M5 Junction 10 Improvements Scheme

Application by Gloucestershire County Council for an order granting Development Consent for the M5 Junction 10 Improvements Scheme

Advice following issue of decision to accept the application for examination – Planning Act (2008) as amended - Section 51

CROSS-SECTION LOCATION PLAN
1:500

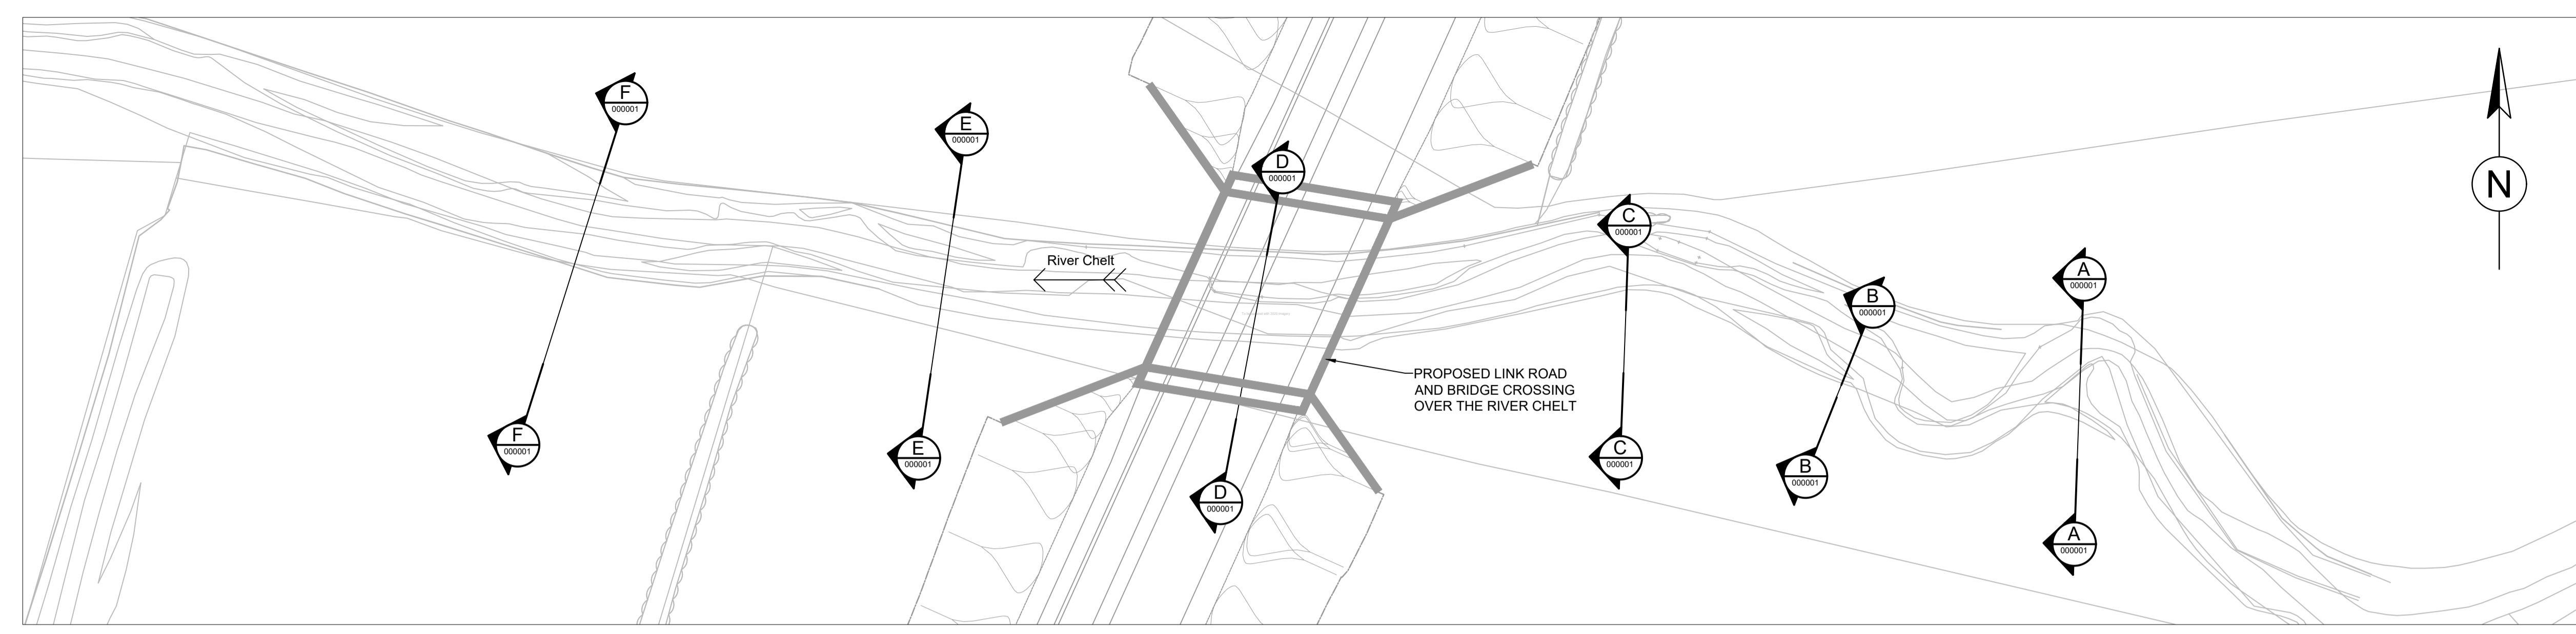
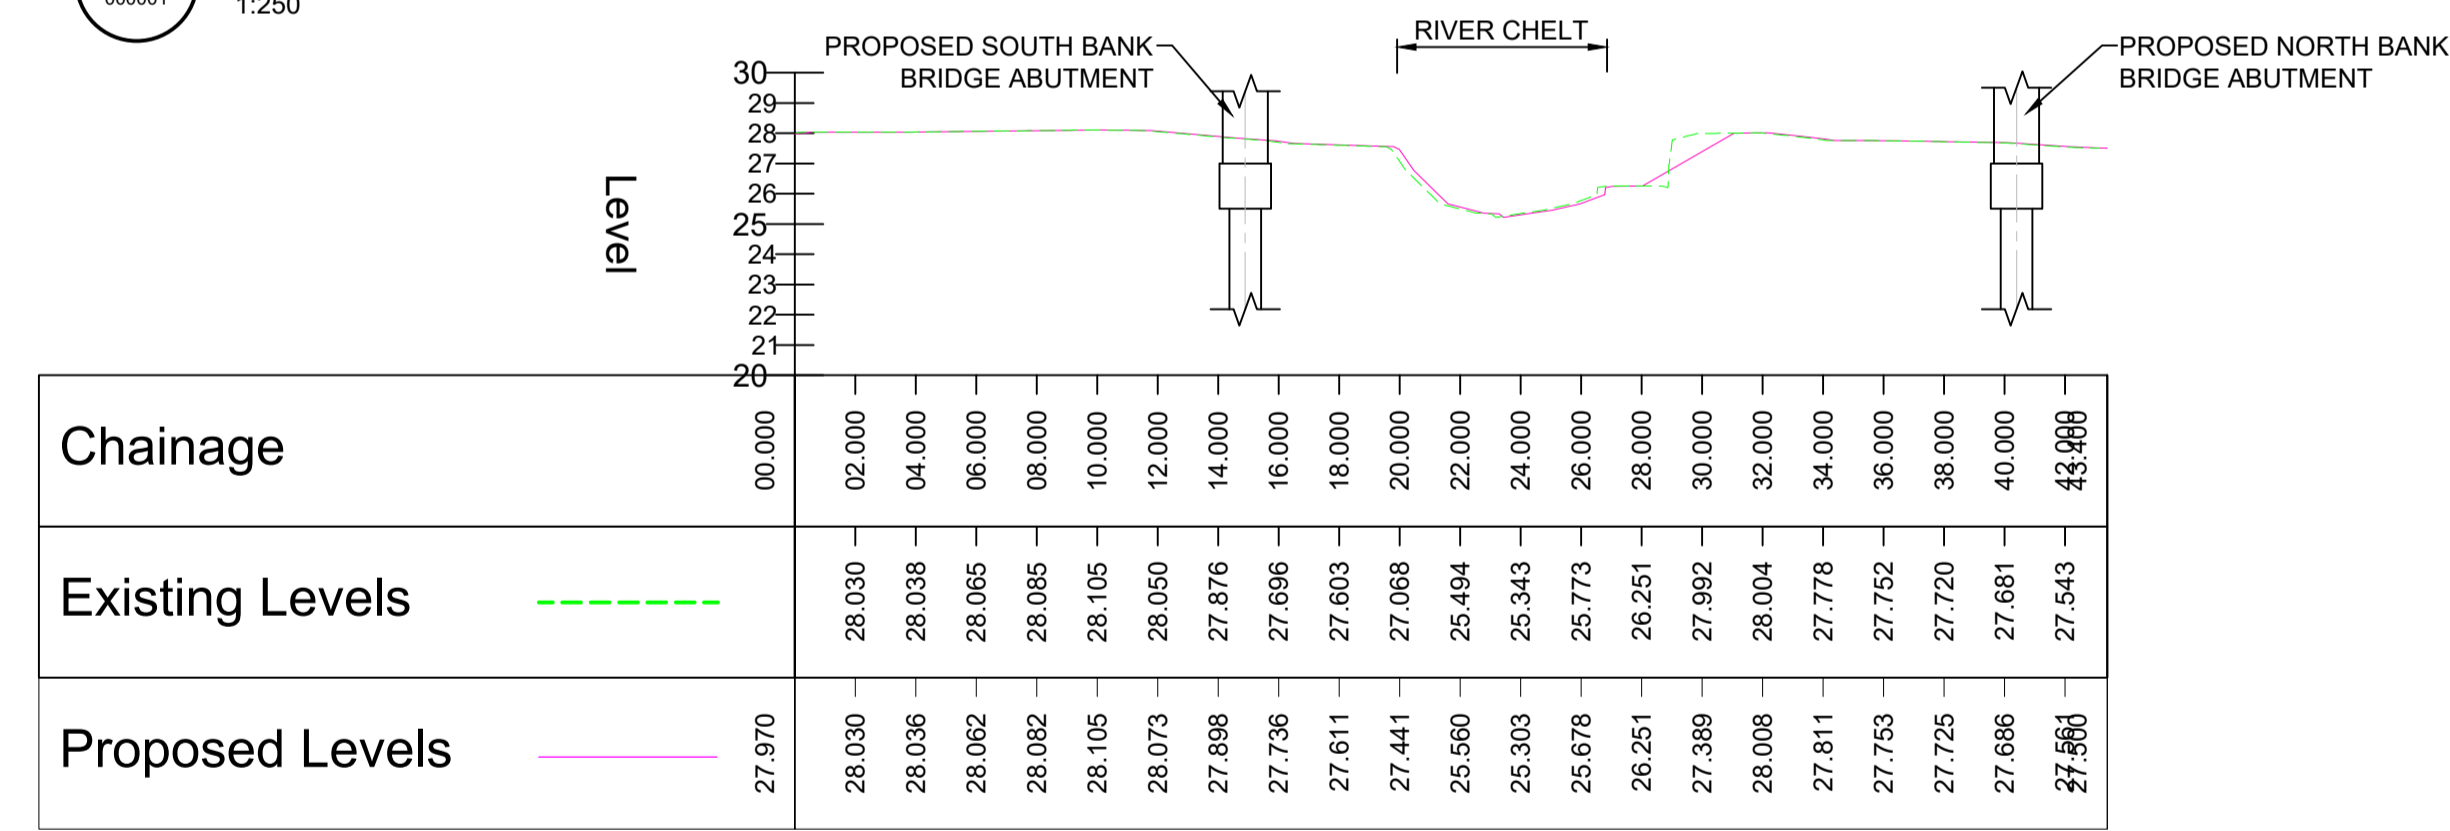
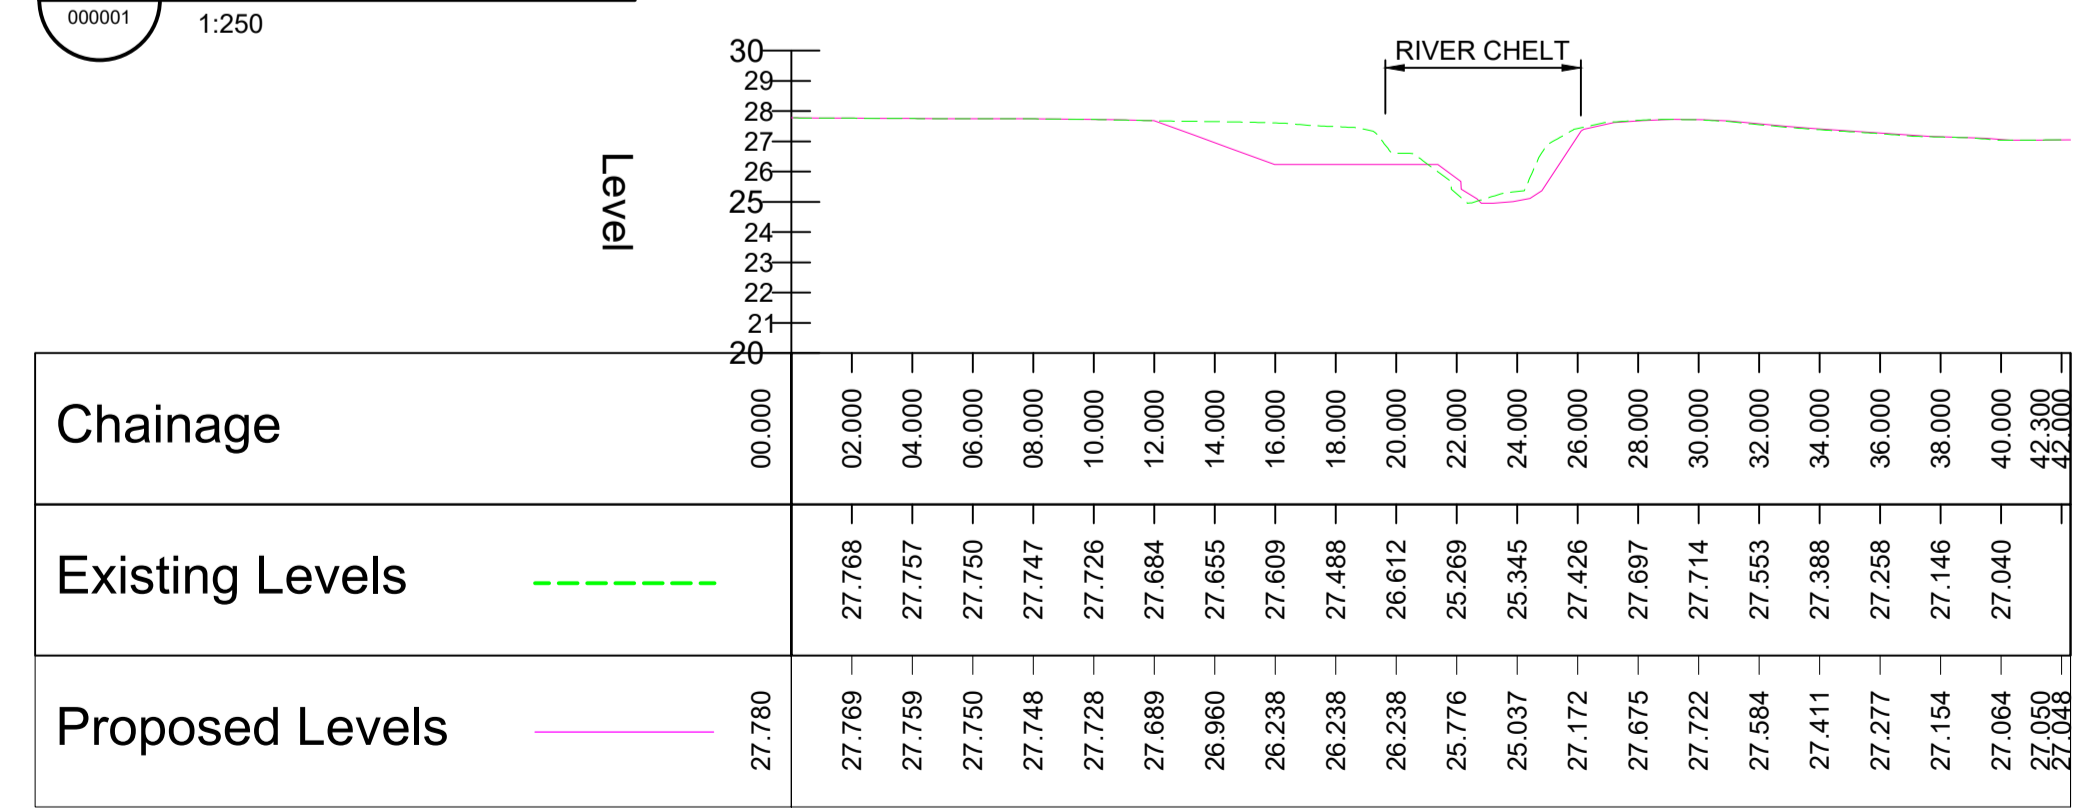
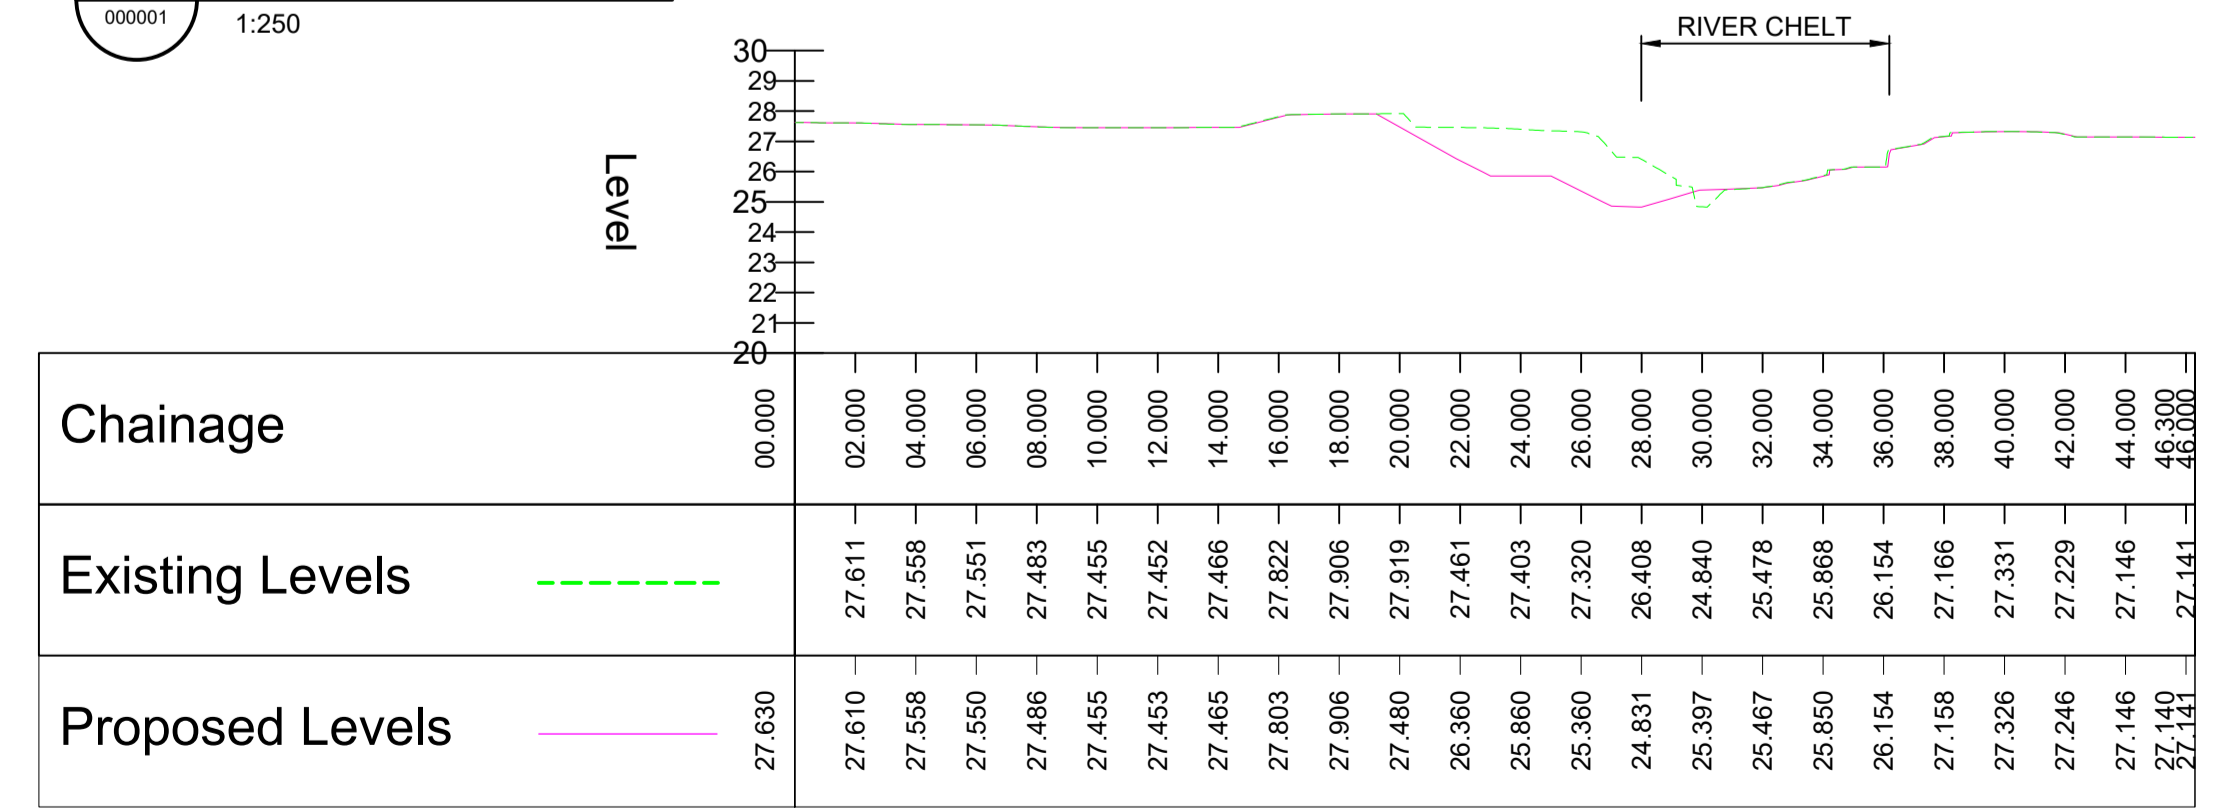
PINS comment: The final plan in the second part of the Environmental Master Plan is the “Proposed Indicative River Chelt Link Road River Cross-Sections” and should be removed as it does not appear to be part of the correct document.

Applicant response: The Applicant considers that this figure should be included as part of the Environmental Masterplans as it provides information on Environmental mitigation.
